# CITY OF ALBUQUERQUE

April 19, 2016

**Re: Eclectic Restaurant Renovation**  
**2119 Menaul Blvd. NE**  
Traffic Circulation Layout  
**Architect's Stamp Date: 4/8/2016; H16D002**

TRAFFIC CIRCULATION LAYOUT
APPROVED
Signature: [Signature]
Date: 4/21/16

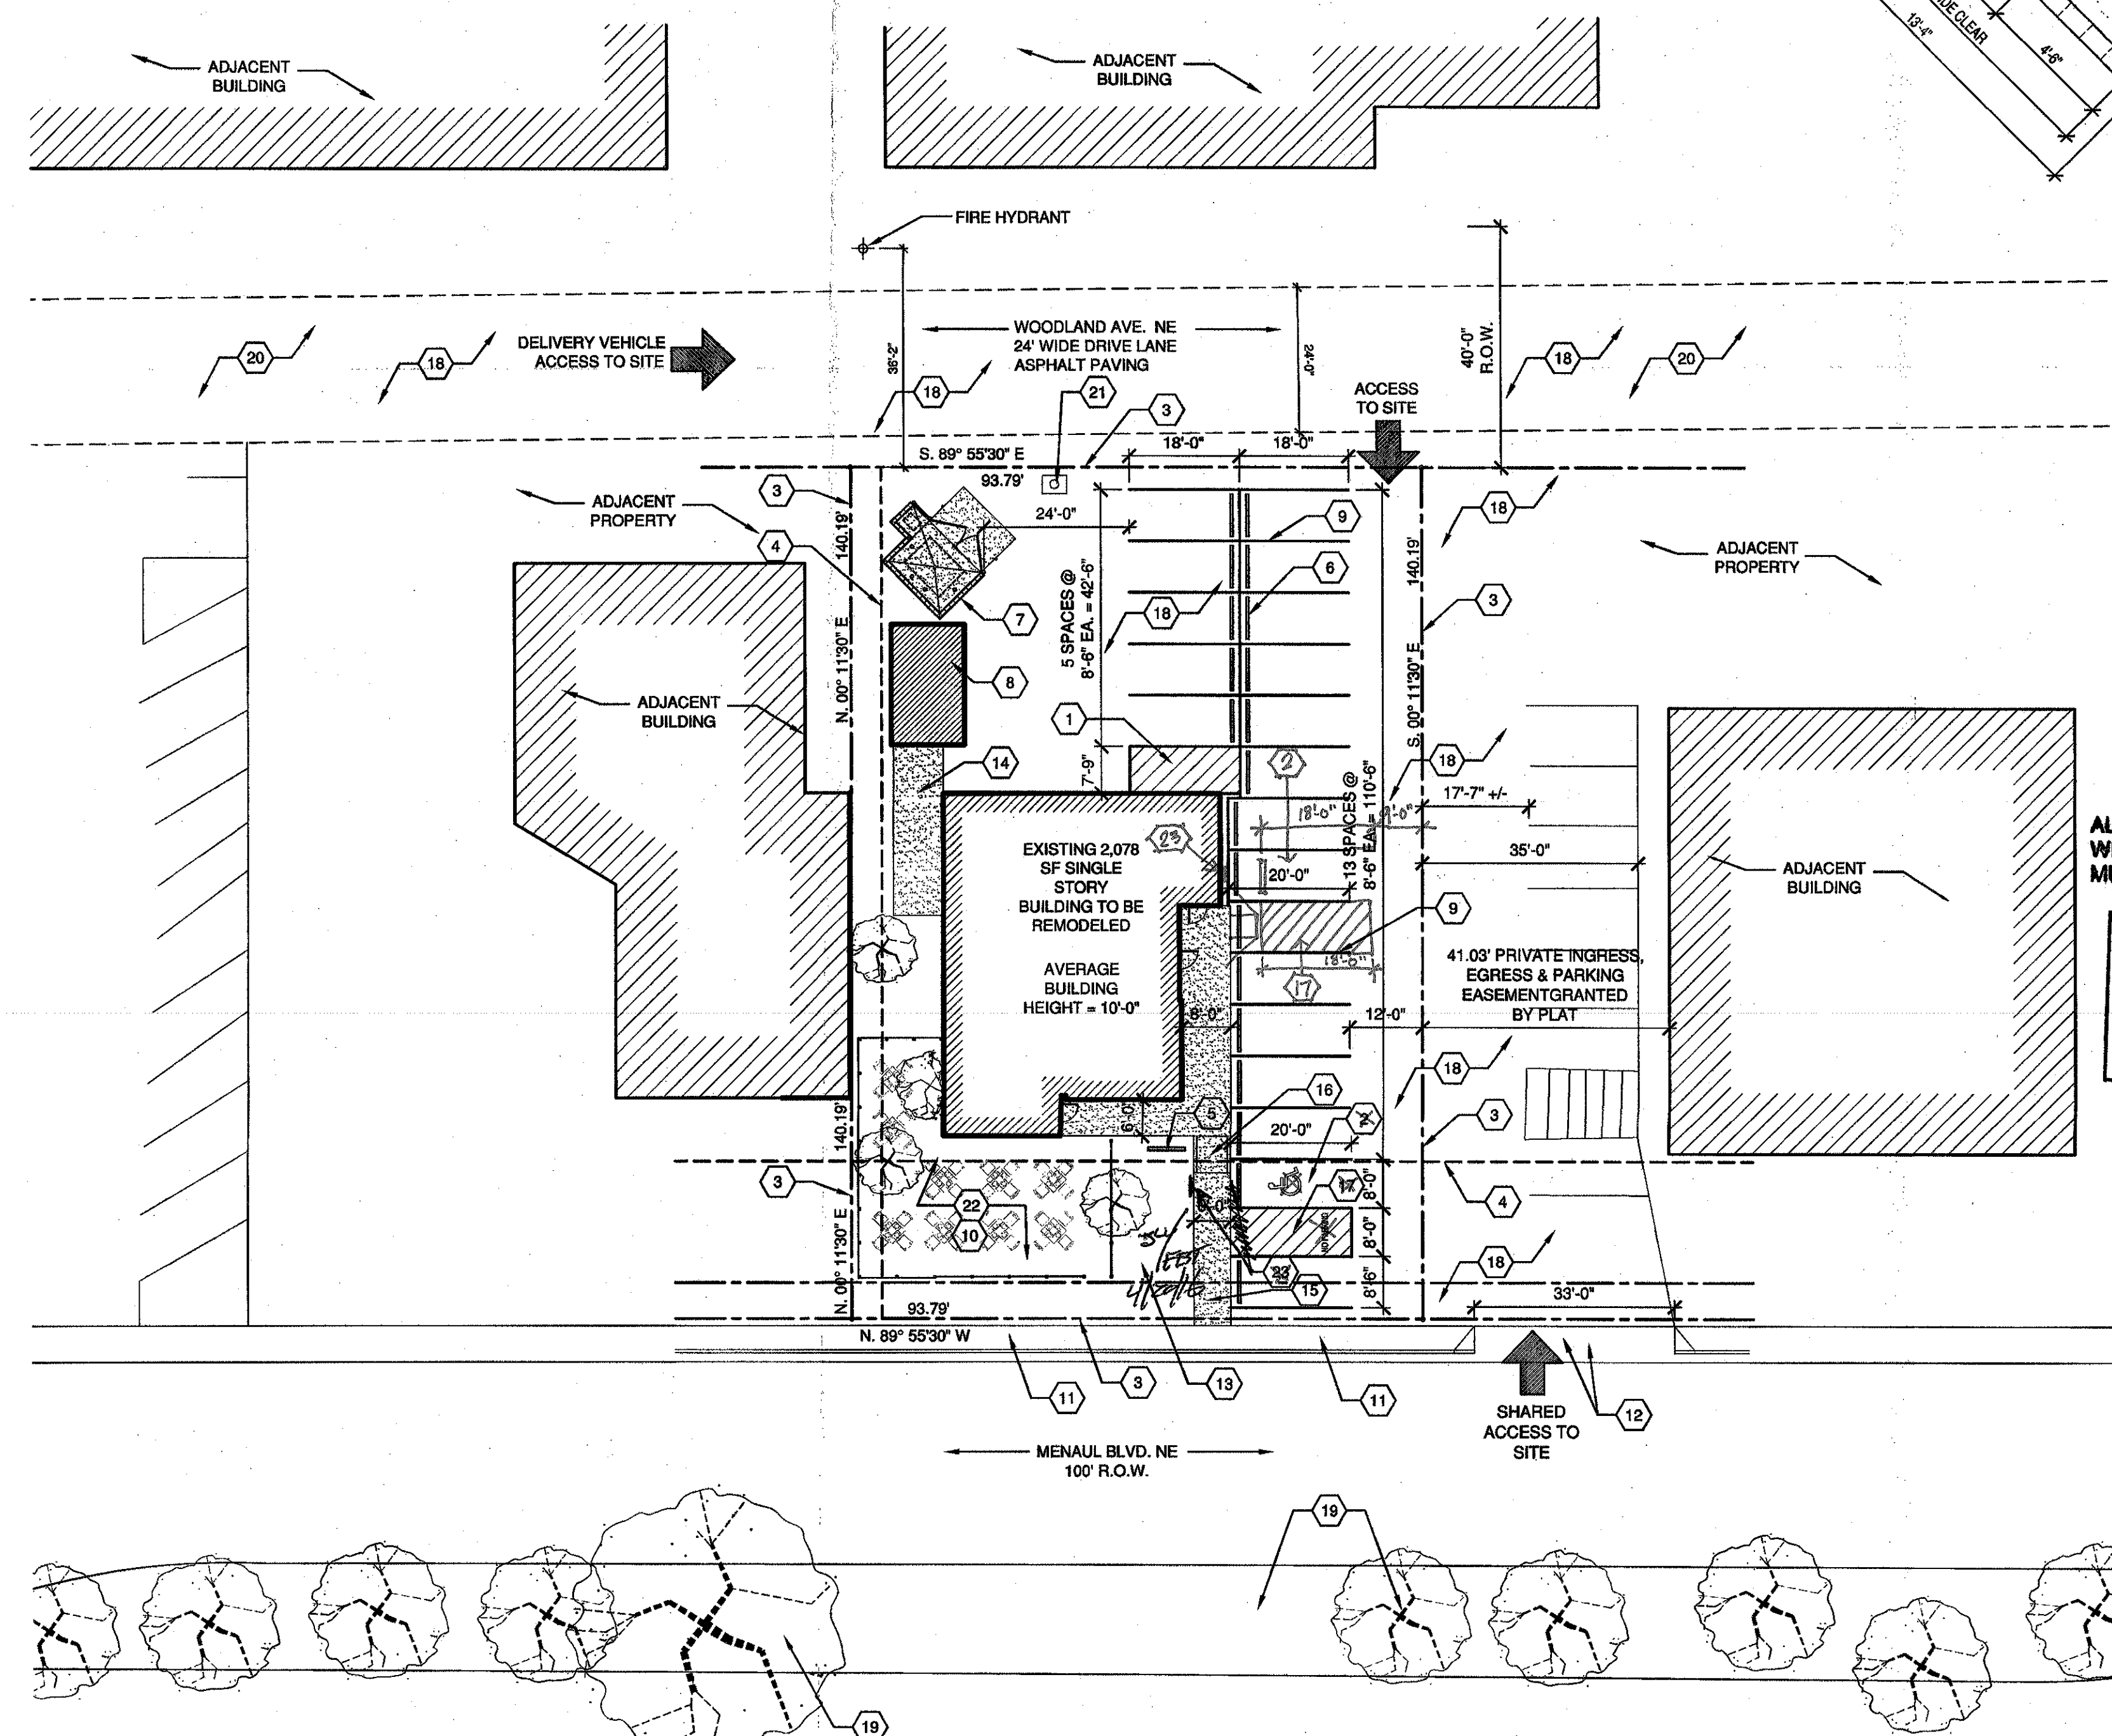
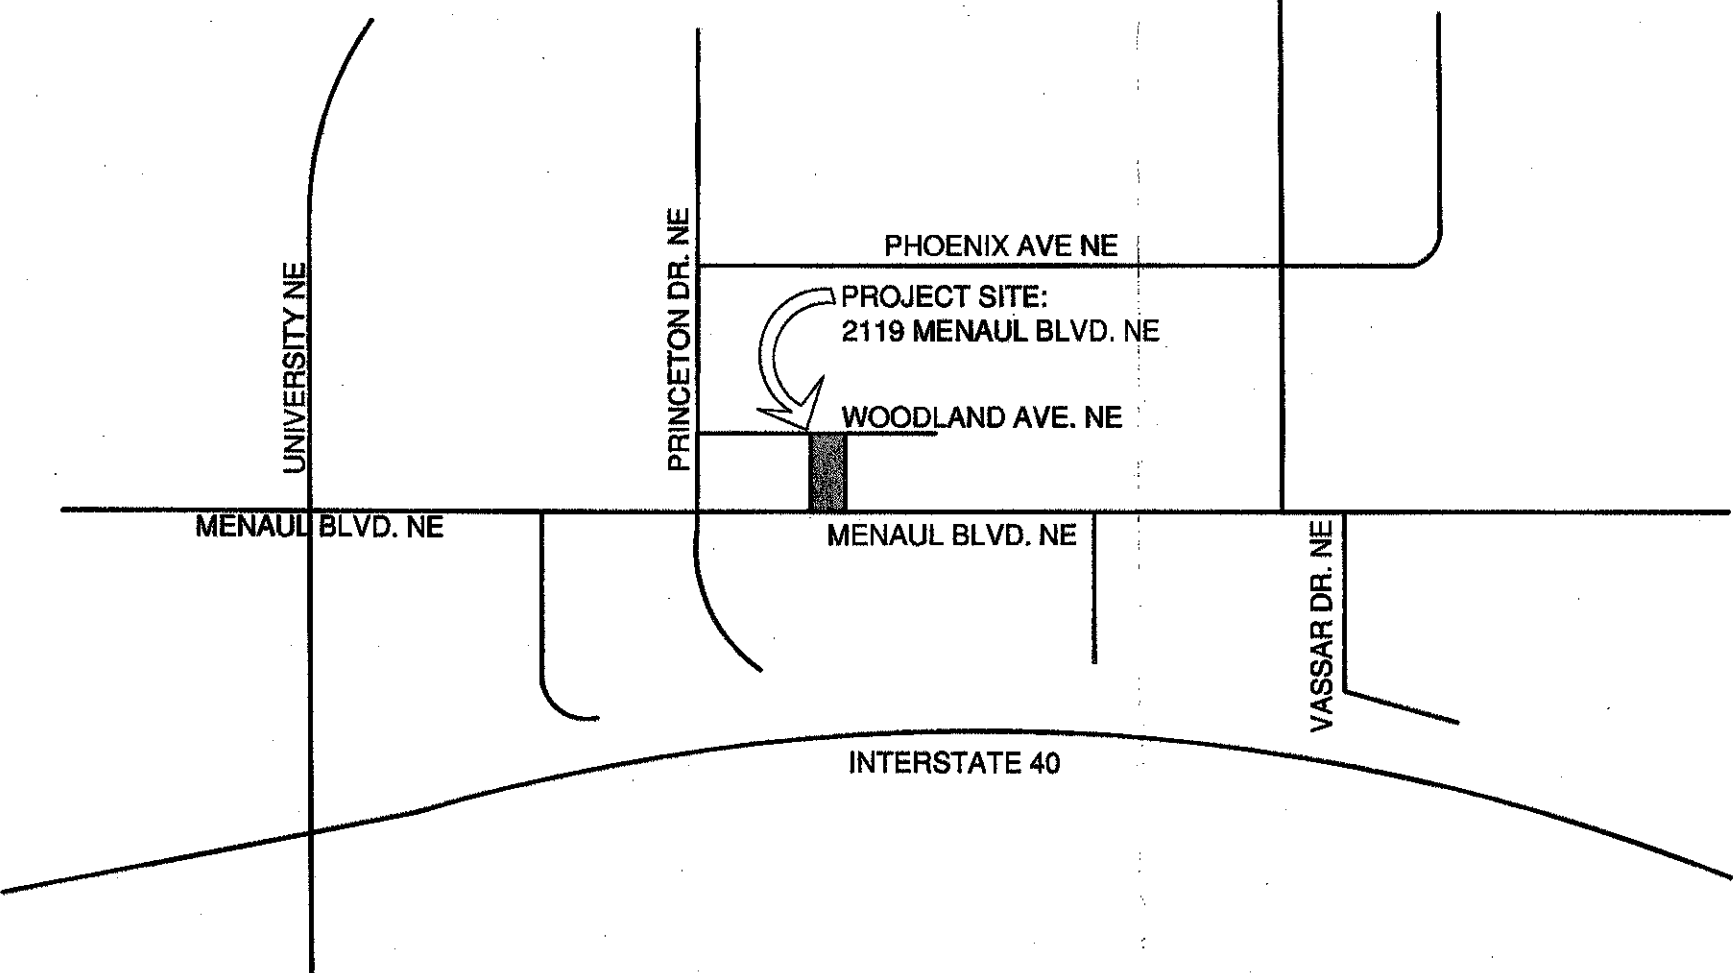
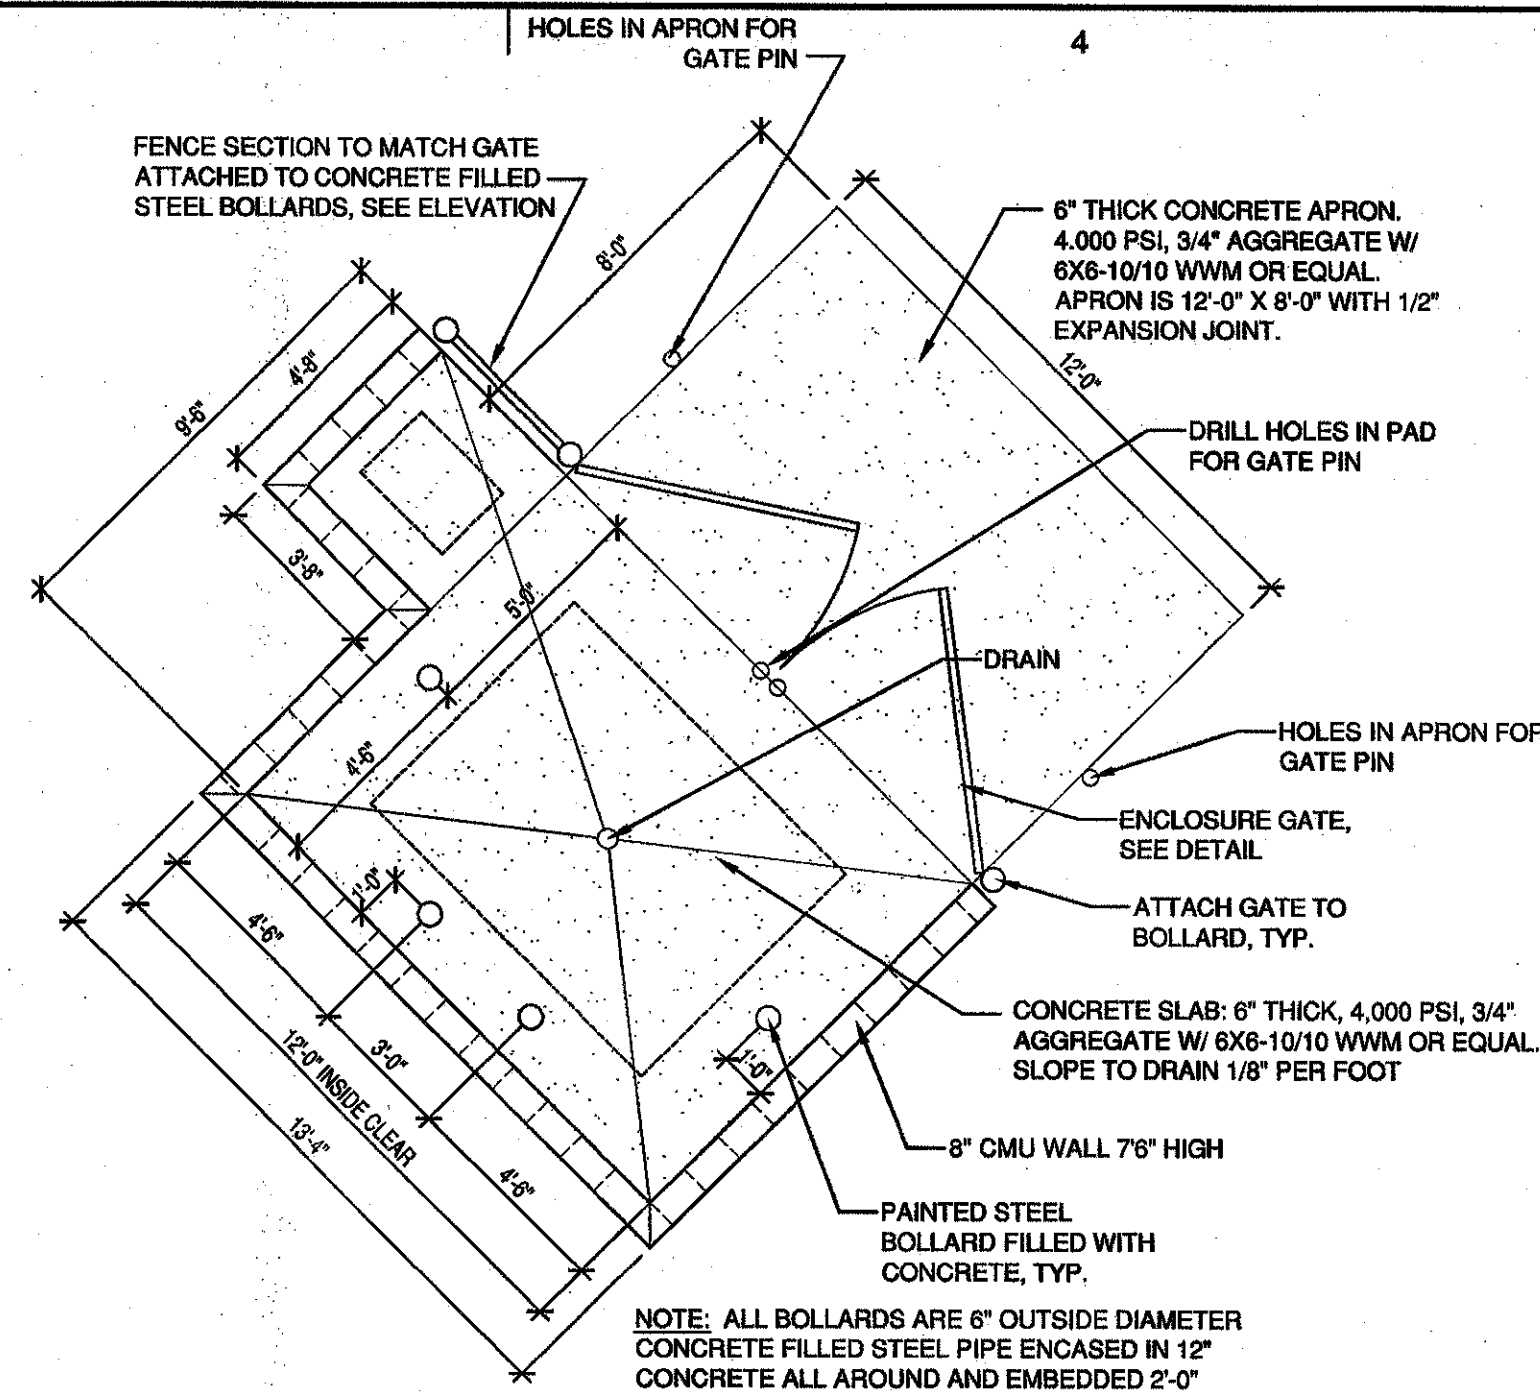
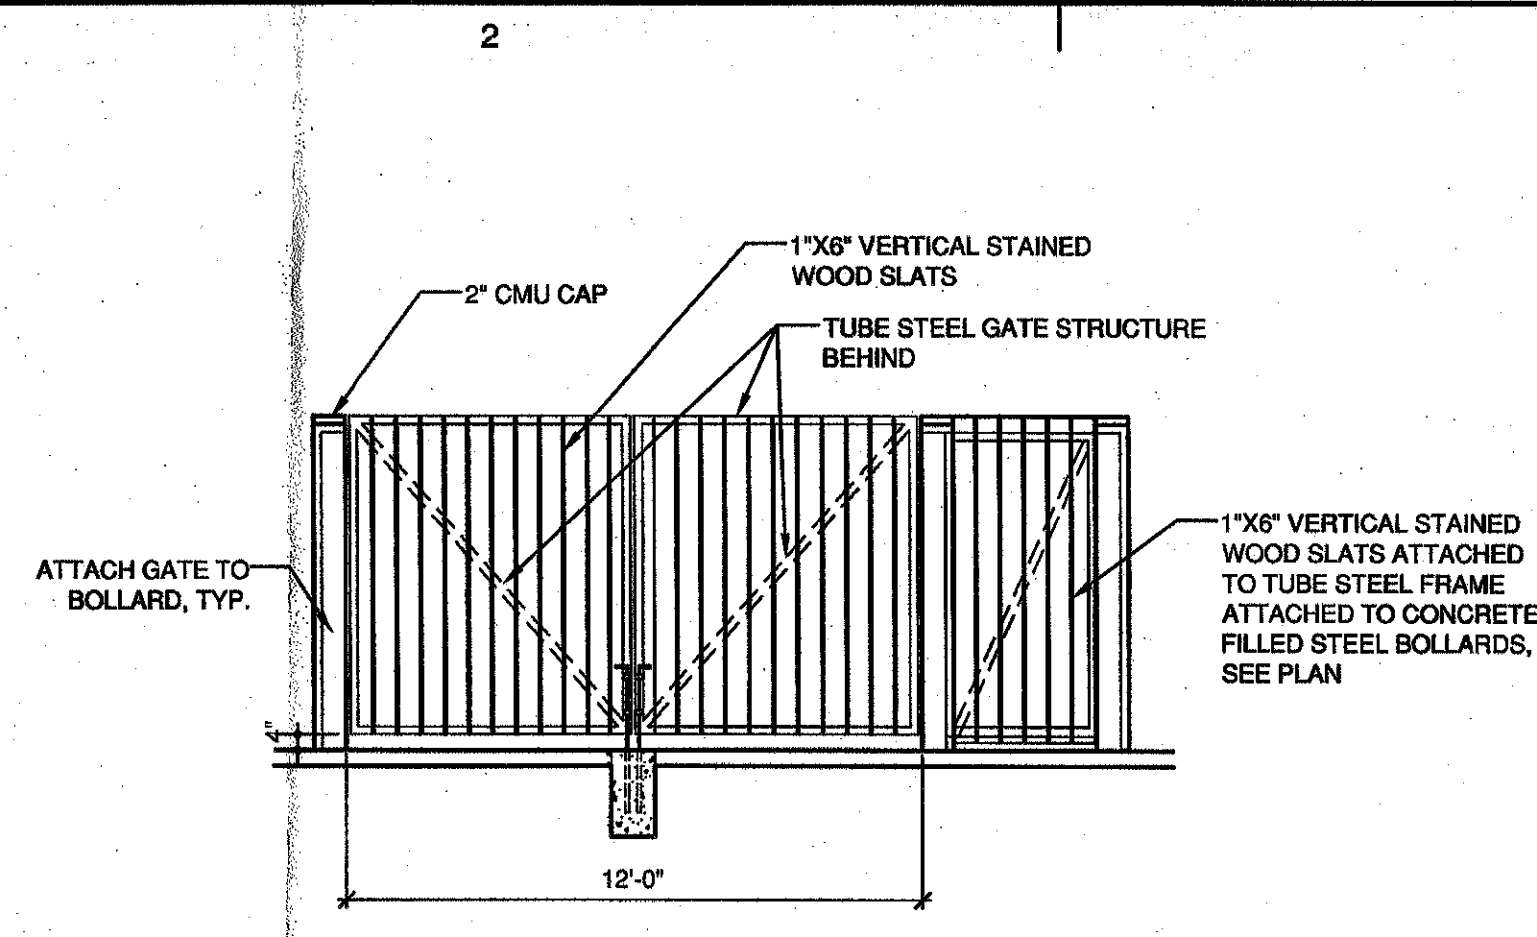
3. Identify the width of the curb cut adjacent to Menaul Blvd.
4. The ADA accessible parking sign must have the required language per 66-7-352.4C NMSA 1978 **"Violators Are Subject to a Fine and/or Towing."** Please call out detail and location of HC signs.

5. The ADA access aisles shall have the words **"NO PARKING"** in capital letters, each of which shall be at least one foot high and at least two inches wide, placed at the rear of the parking space so as to be close to where an adjacent vehicle's rear tire would be placed. (66-1-4.1.B NMSA 1978)

10. Please specify the City Standard Drawing Number when applicable, for example, new sidewalk, new accessible ramp (Keyed Note 16), etc.
11. Is the accessible ramp (Keyed note 16) proposed or existing? If existing, does it meet ADA design standards?
